**Town & Country Planning Act 1990 (as amended)
Town and Country Planning (Development Management Procedure) (England) Order 2015
Application for Planning Permission**

Development To install 1 no. electrically operated external roller shutter door.

Location 14 Finisterre Way Littlehampton

**BLOCK PLAN
5991 LITTLEHAMPTON**

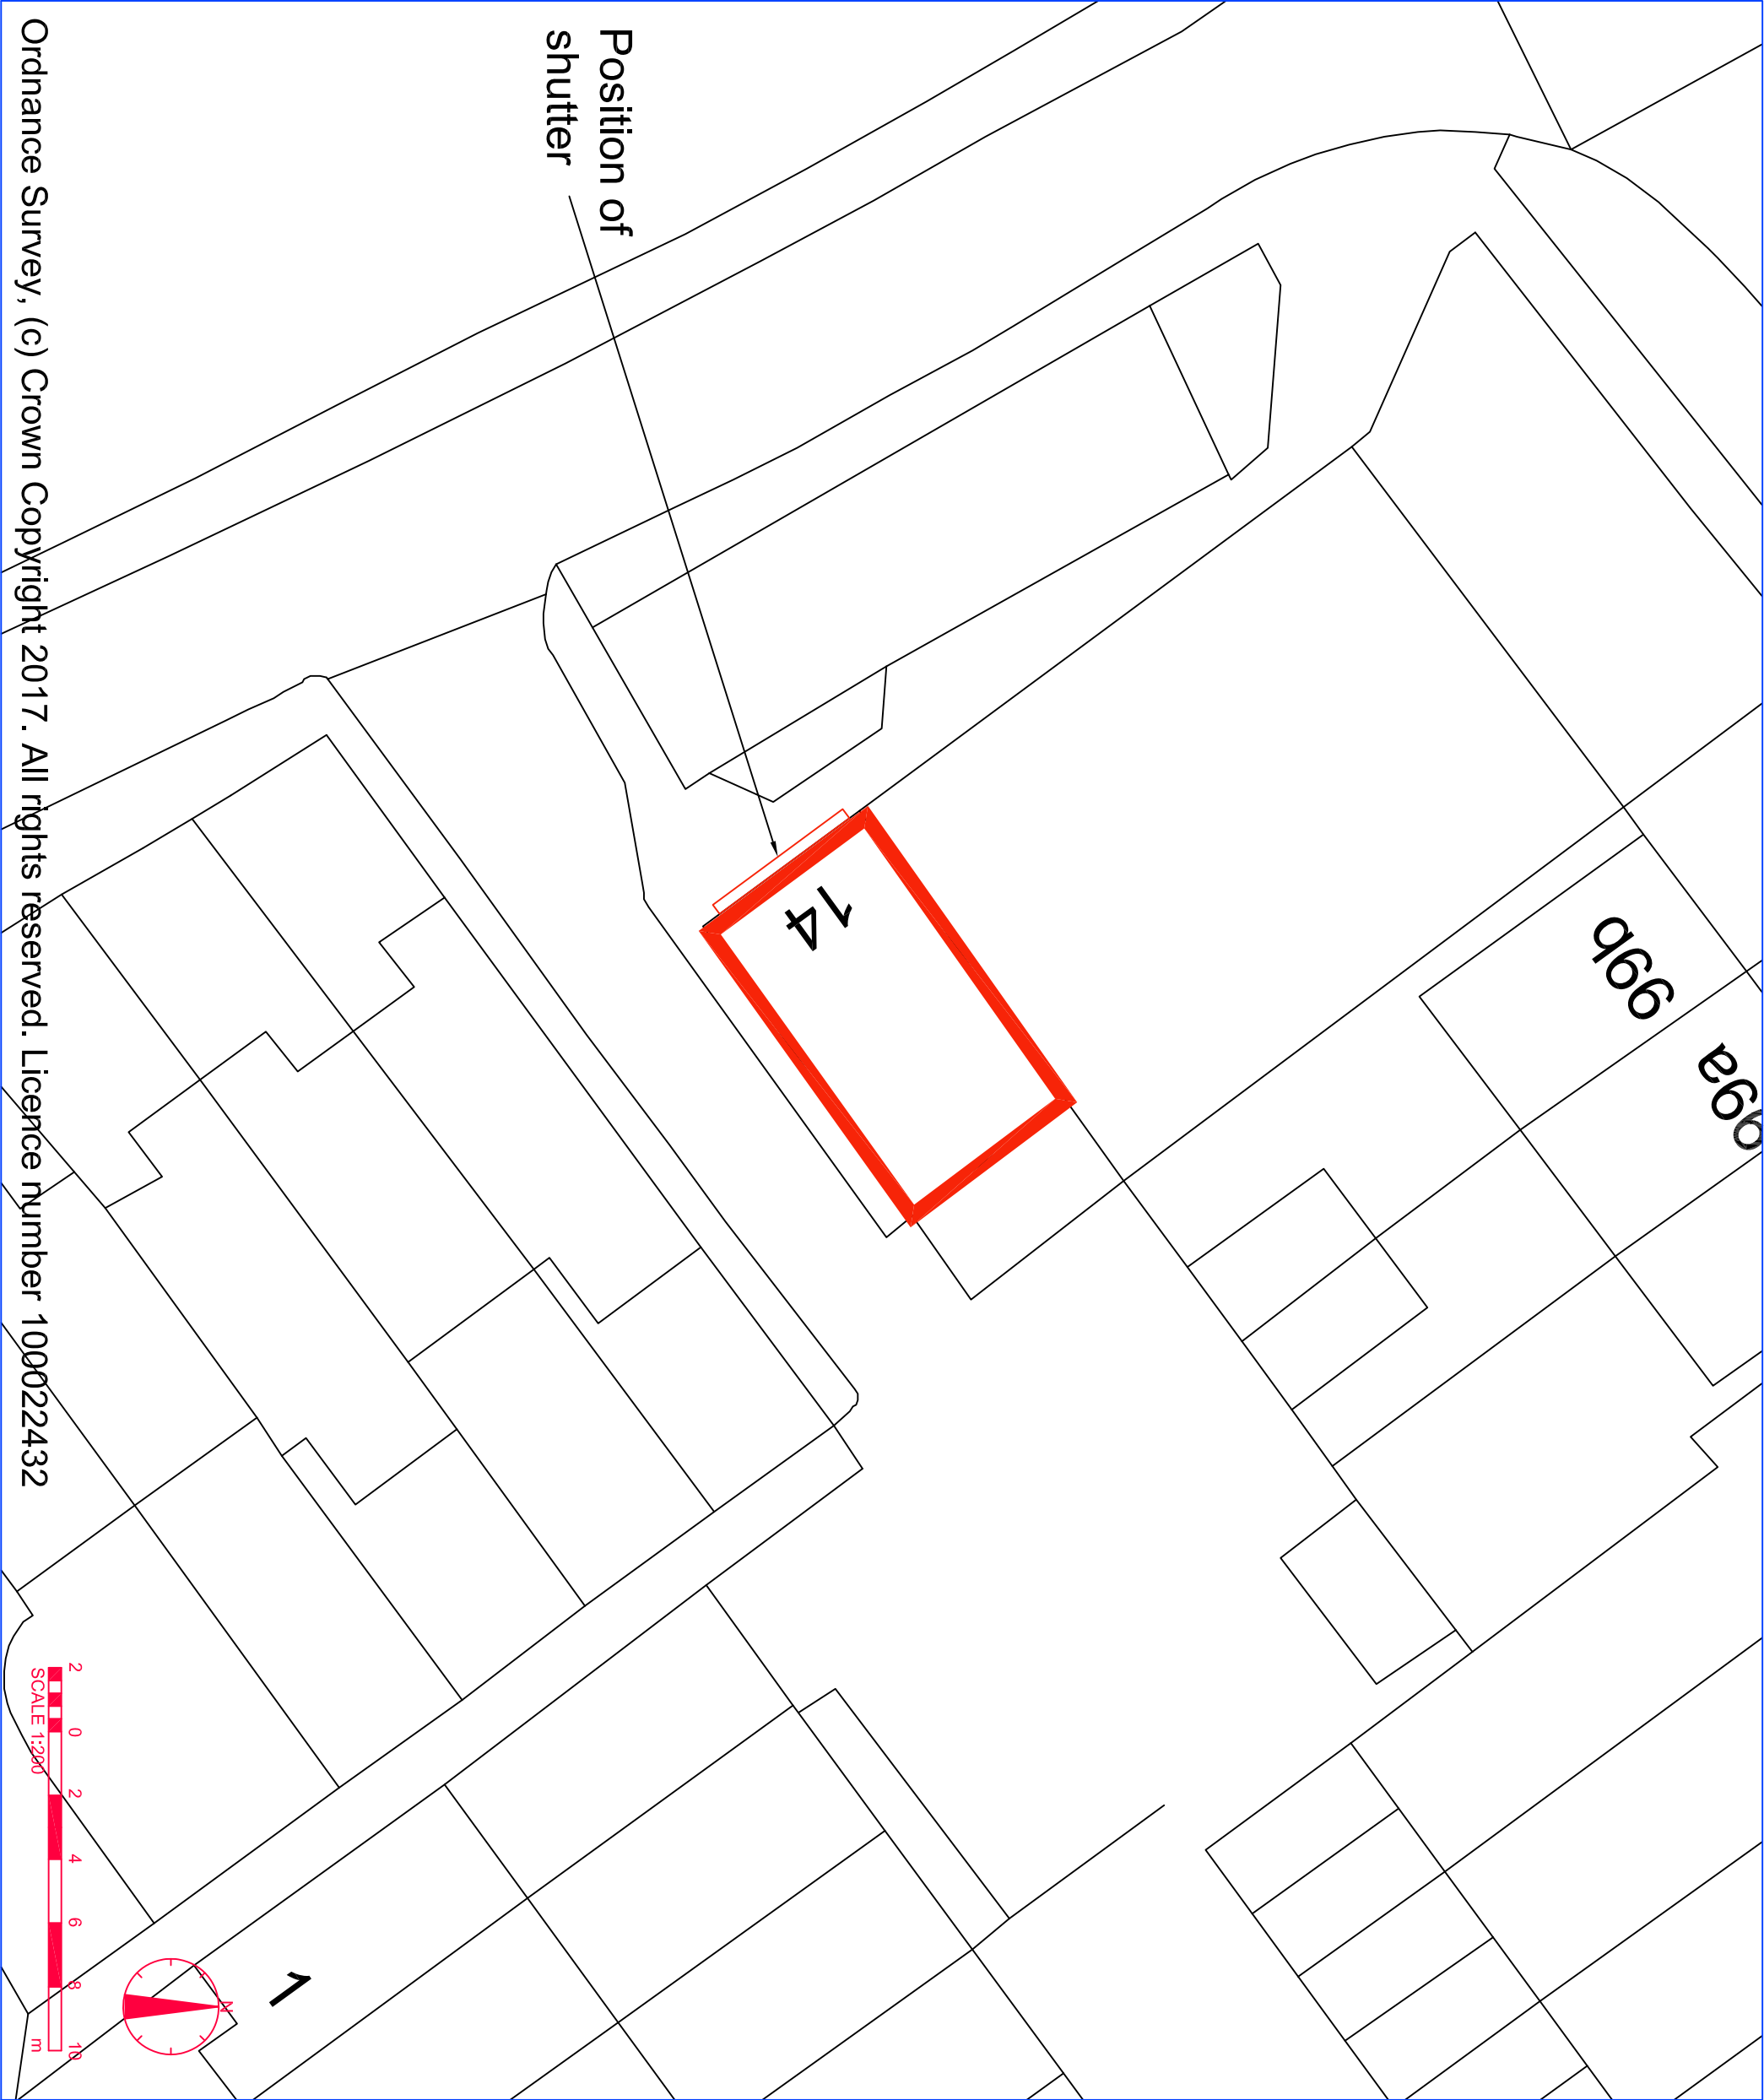
Block Plan - Amend

Please submit 1 electronic or 3 paper copies of an amended block/site plan at a scale of 1:500 or 1:200 to include the proposals (position of works) indicated on the plan. Further details of what must be included on the plan can be found in the National Validation Requirements.
